Consultation Response from KC,
Lead Local Flood Authority

2026/91775 land at, Dowker Street, Milnsbridge, Huddersfield, HD3 4JU

Discharge of details reserved by conditions 4 (C(E)MP), 5 (CEMP: Biodiversity), 6 (road survey), 7 (retaining walls), 9 (surface water features in the Highway), 10 (culvert condition survey of Longwood Brook), 11 (Drainage Strategy), 12 (Flood routeing), 13 (temp drainage), 14 (Phase 1 Report), 15 (Phase 2 Report), 16 (Remediation), 18 (Estate road specification), 19 (access specification), 20 (footpath connection specification), 21 (Boundary Treatment), 23 (Acoustic report), 24 (facing materials), 25 (roofing materials), 29 (Landscape strategy) on previous permission 2025/92728 for erection of 33 dwellings with associated car parking and landscaping

Date Responded: 28th July 2026

DRAINAGE STRATEGY

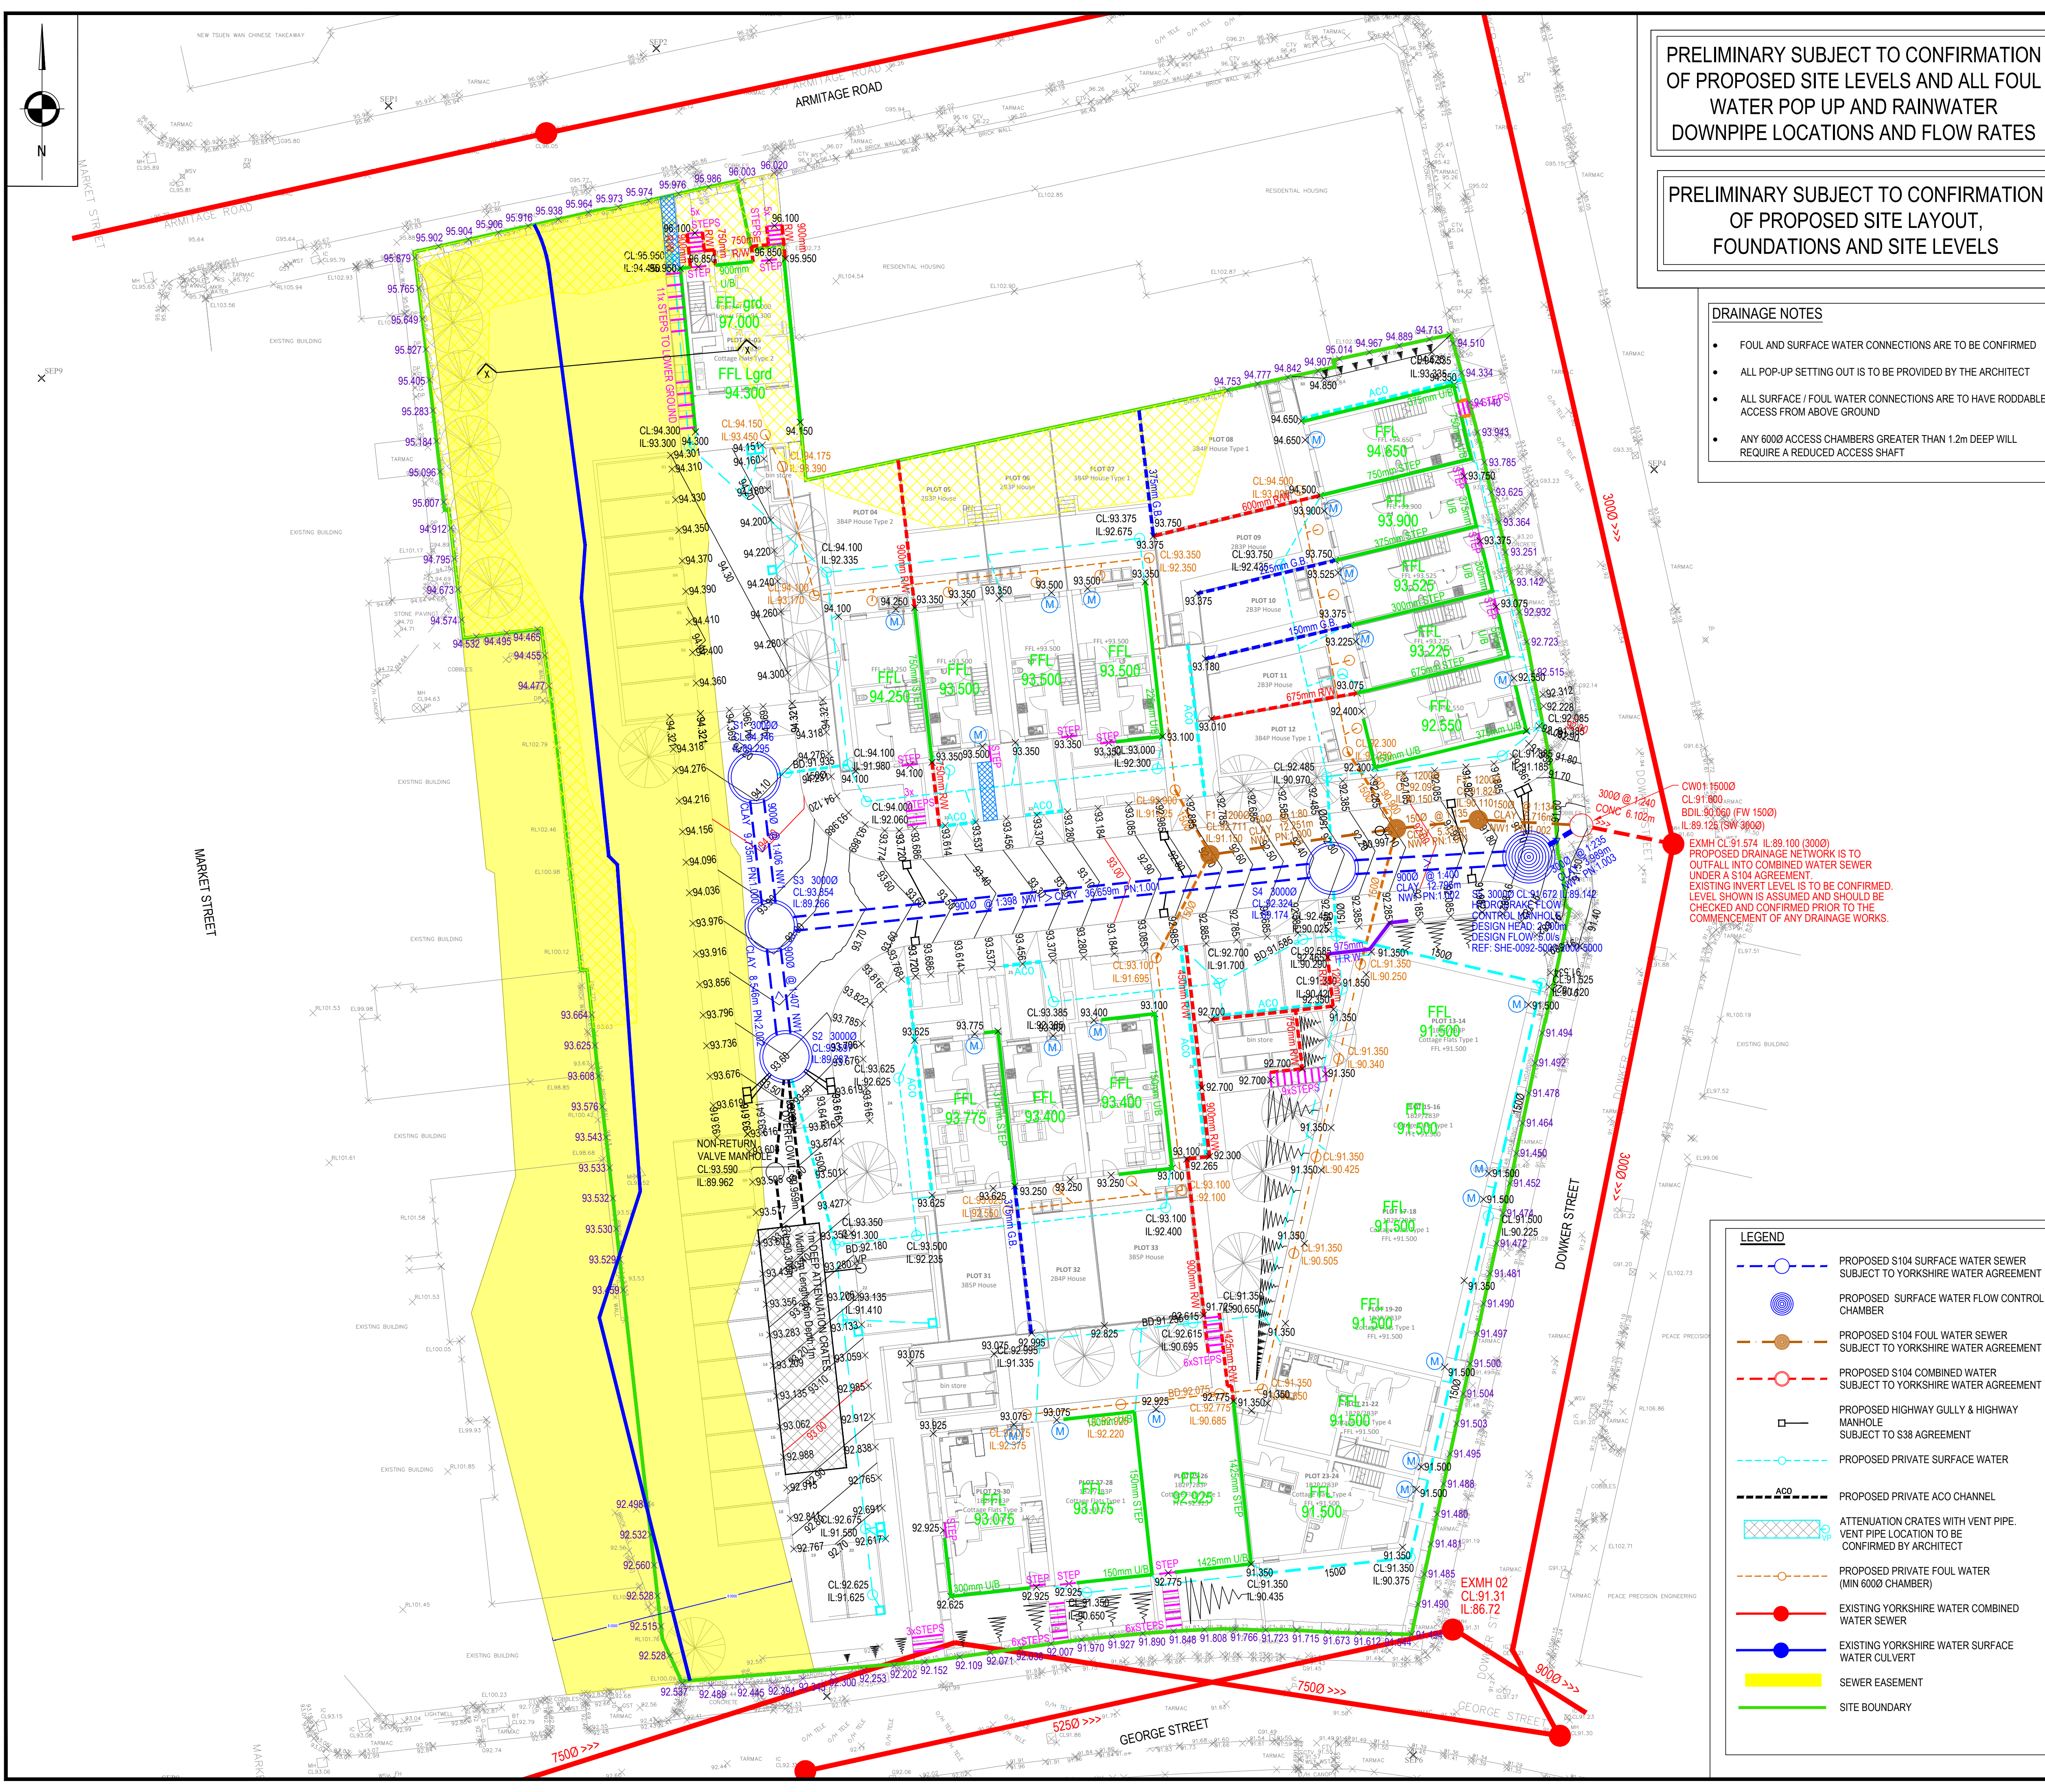
Please note that hydraulic simulation shows an overflow of surface water in the M30_360 event, therefore an attempt to store the 30 years event in pipework has failed. The design is acceptable if the crate storage is adopted as well.

If the above was secured in principle the 'overflow' design could change. However, it is not clear from drawings of the tank whether the above assumption is current, with the incoming pipe not shown in cross sections. Manhole S2 is relevant here.

The type of tank is not specified.

No access is shown on the tank.

It is not clear how sediment build up is to be managed, i.e. jetting and camera.

The current design shows flooding of 10.7 cubic metres which is not acceptable.

A 300mm outlet for 5l/s is shown on drawing (which is large) but no emergency drainage down (penstock/disc valve).

40% not 45% has been used for climate change.

Levels for the existing combined manhole have not been verified according to drawings. As a result it is not known whether the design is buildable
